Re: PA22-023- Brodie Rezone PRD – Technical Review 2

SUBJECT: PA 22-023 – Brodie Subdivision

LAND PRO GROUP, INC.
BRODIE PLAT
 PRELIMINARY ROAD SECTIONS

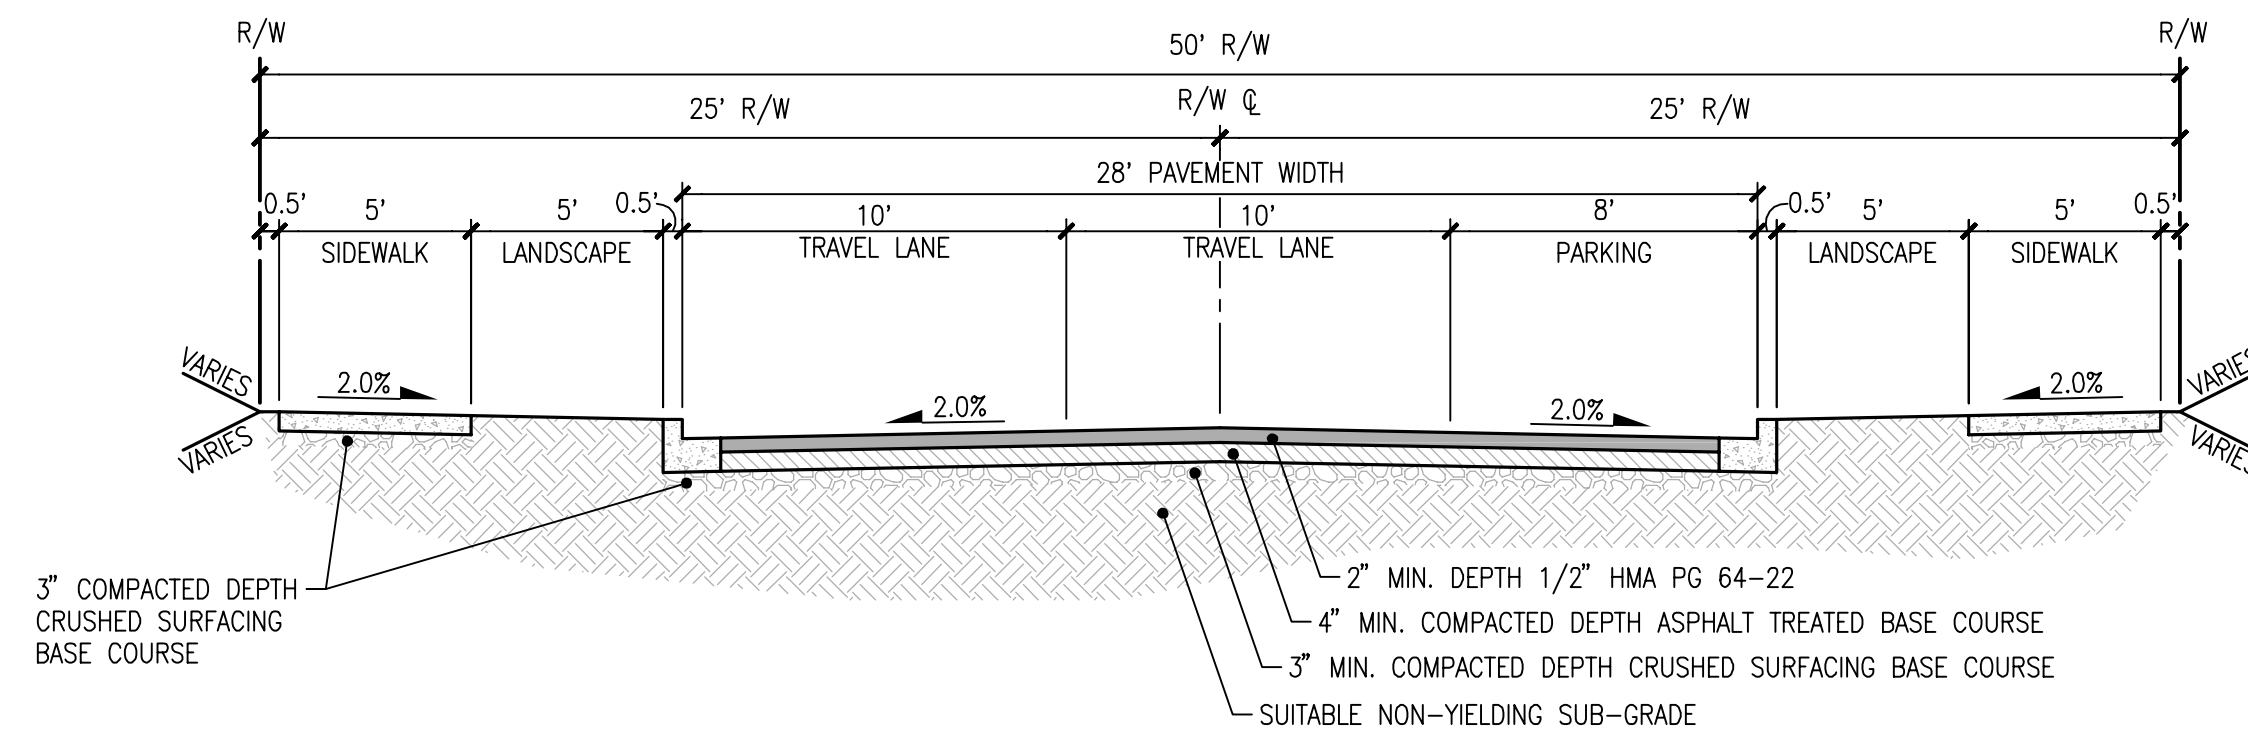
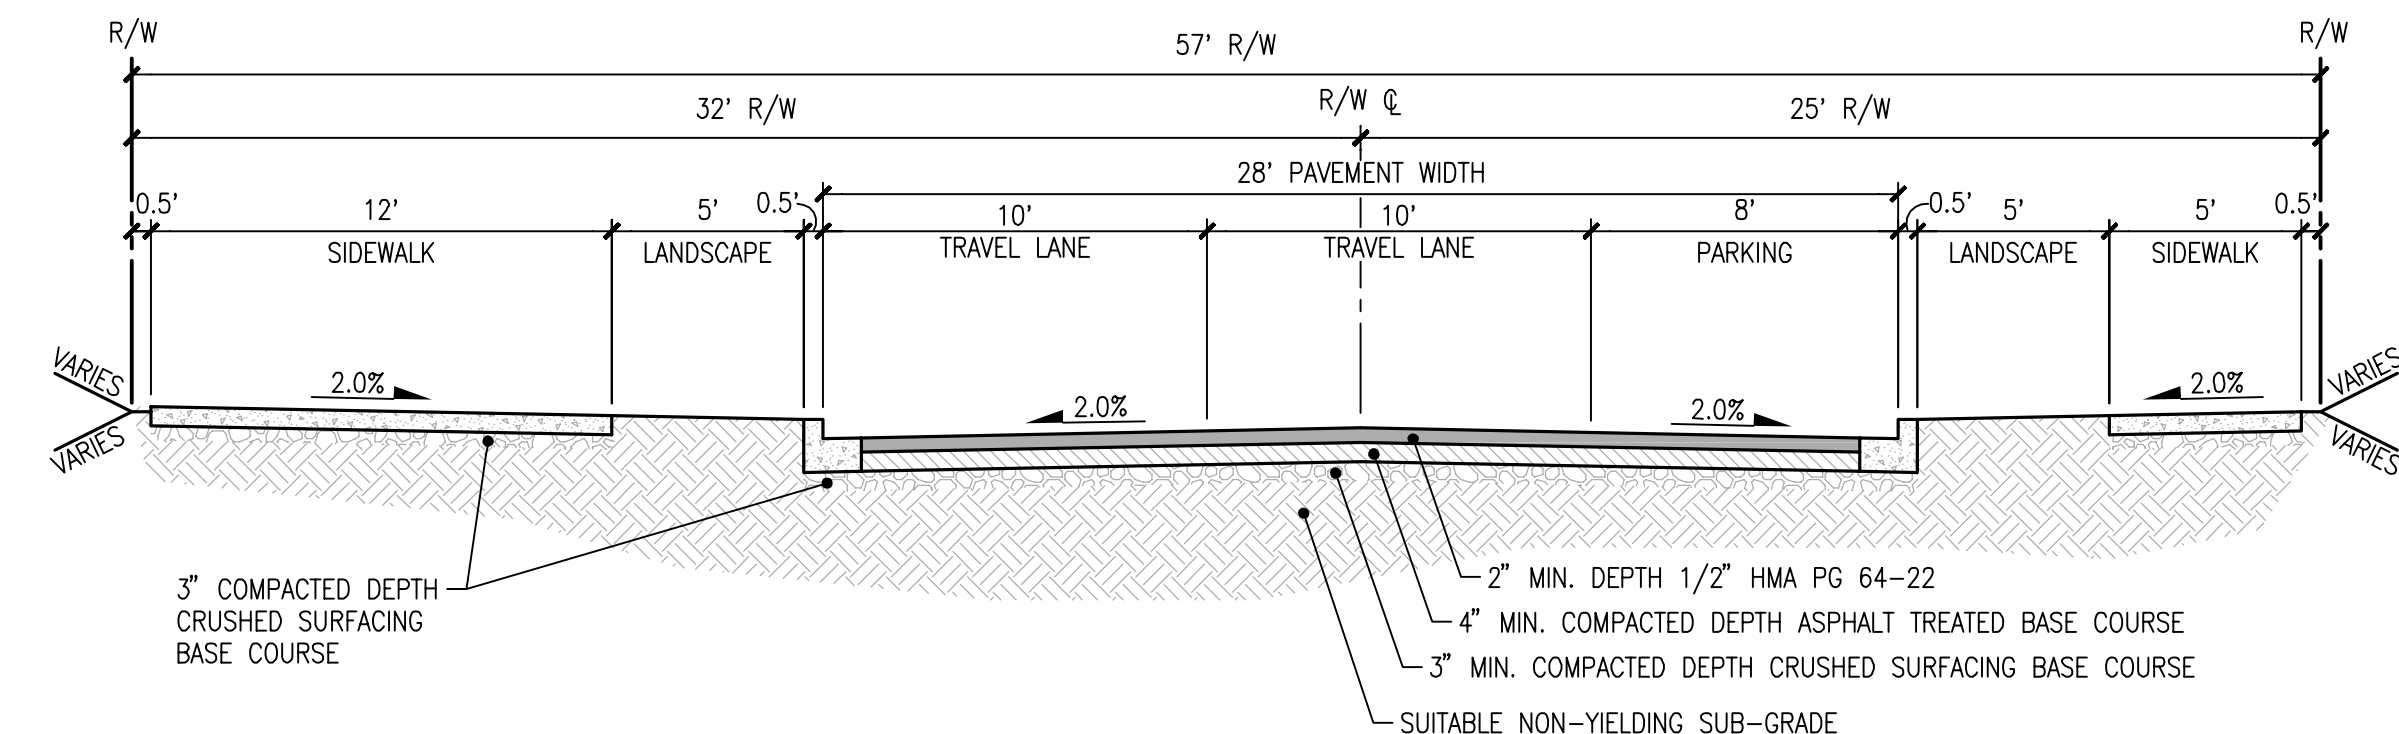
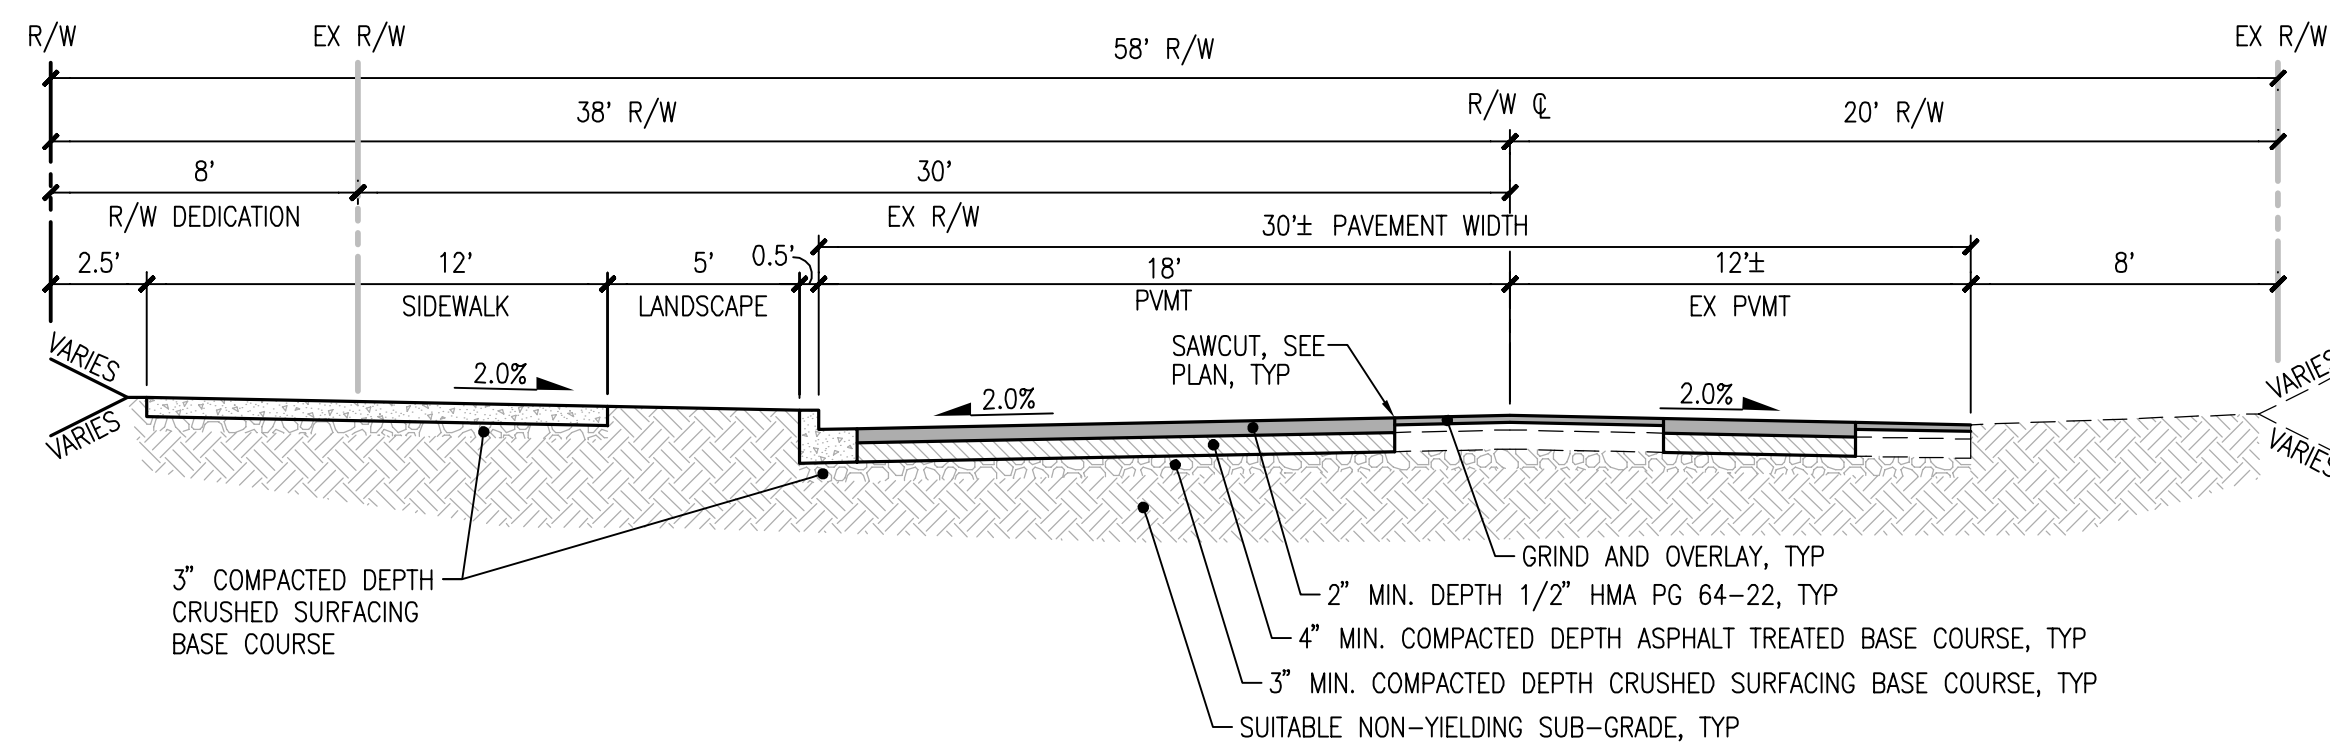
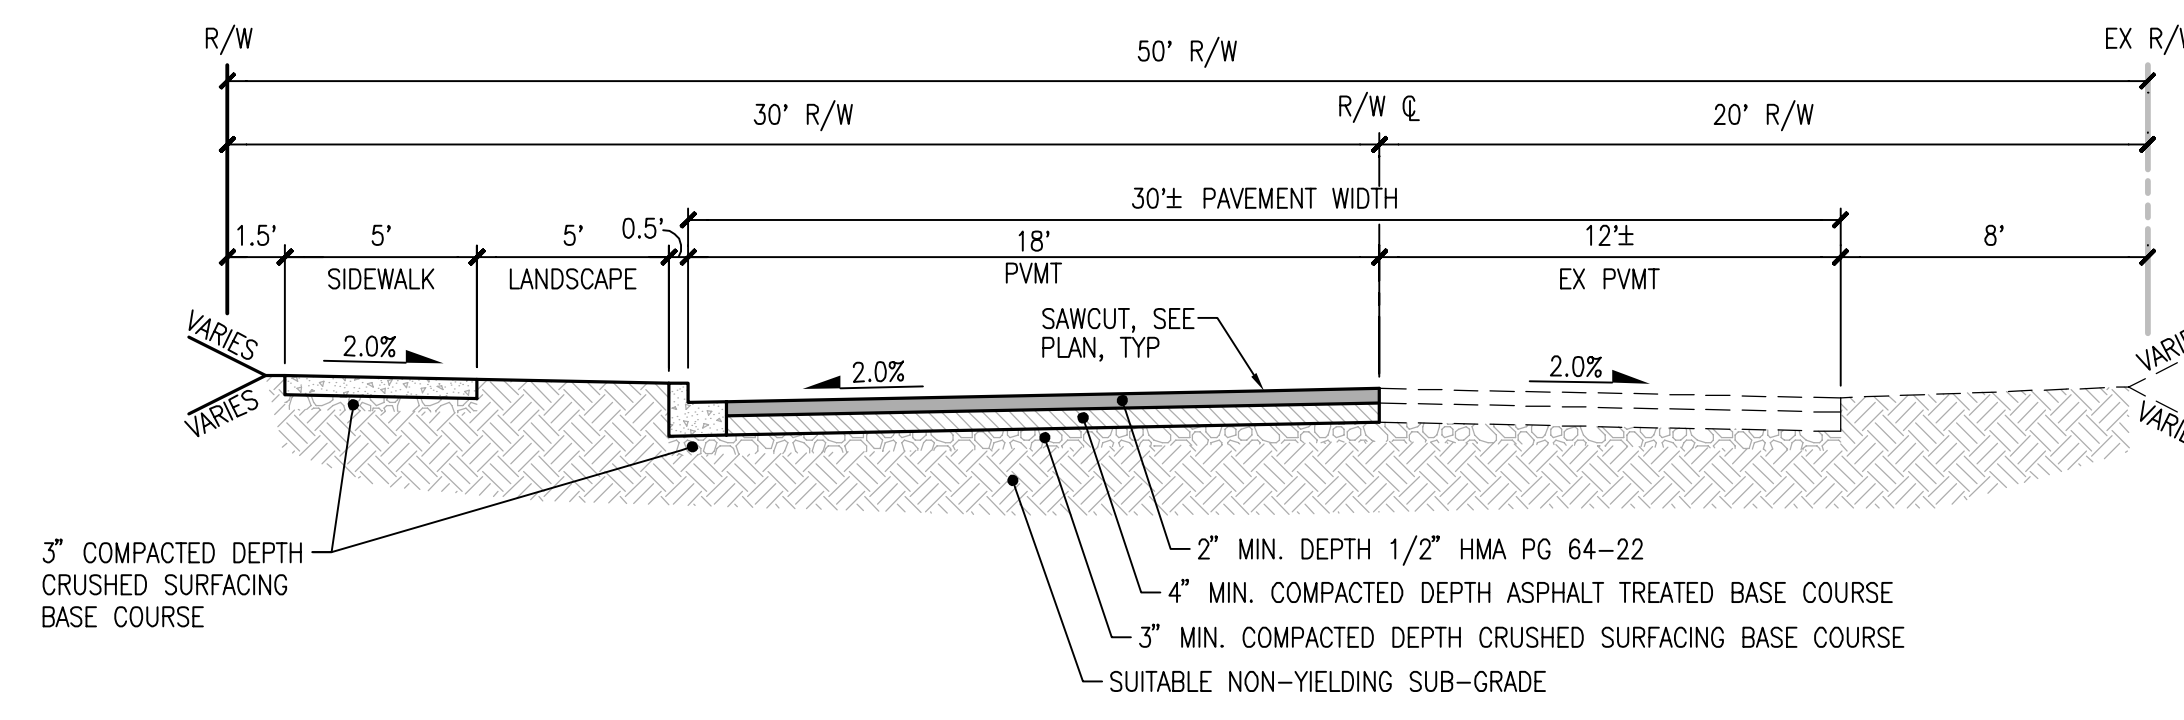
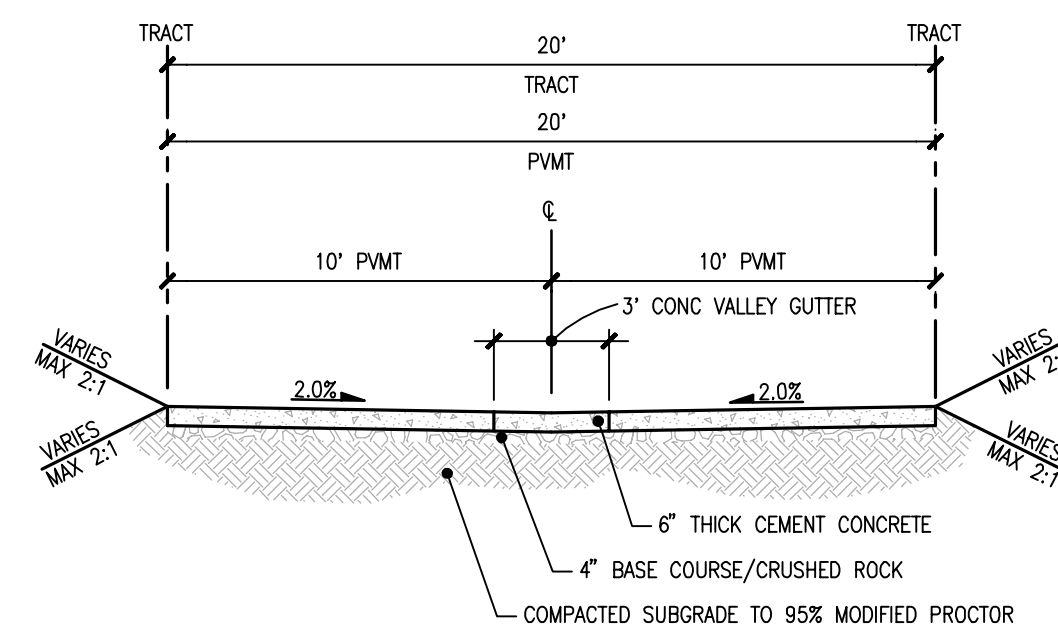
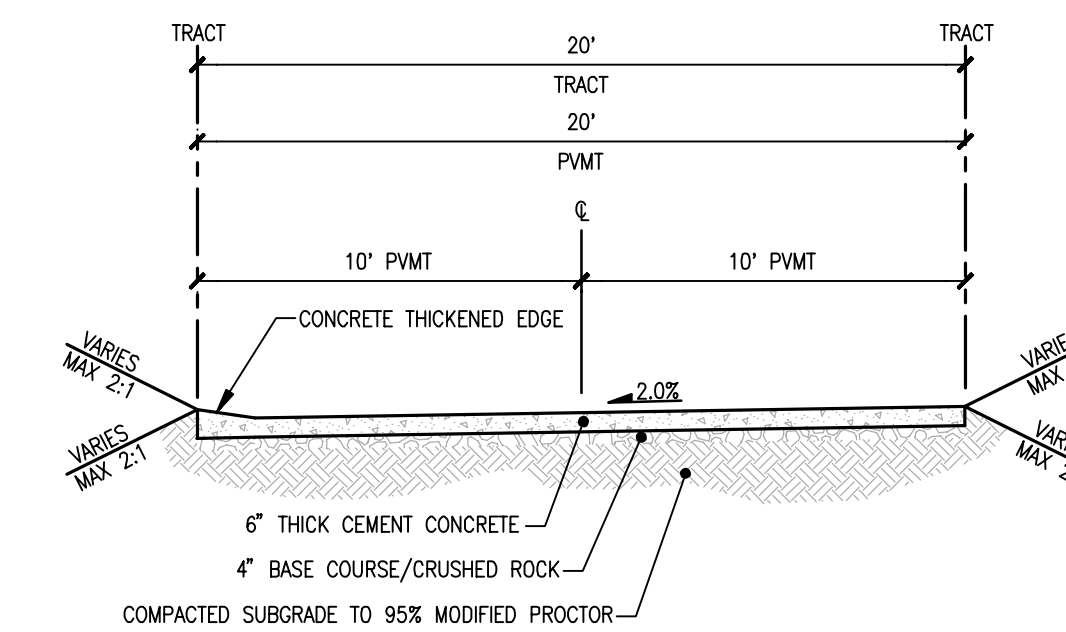
1. Based on the plan sets, there is to be a pervious pathway located along the outer edges of Tract 999. Please include details and “road” section for the proposed pathway to RD-06 of the Civil Plans.
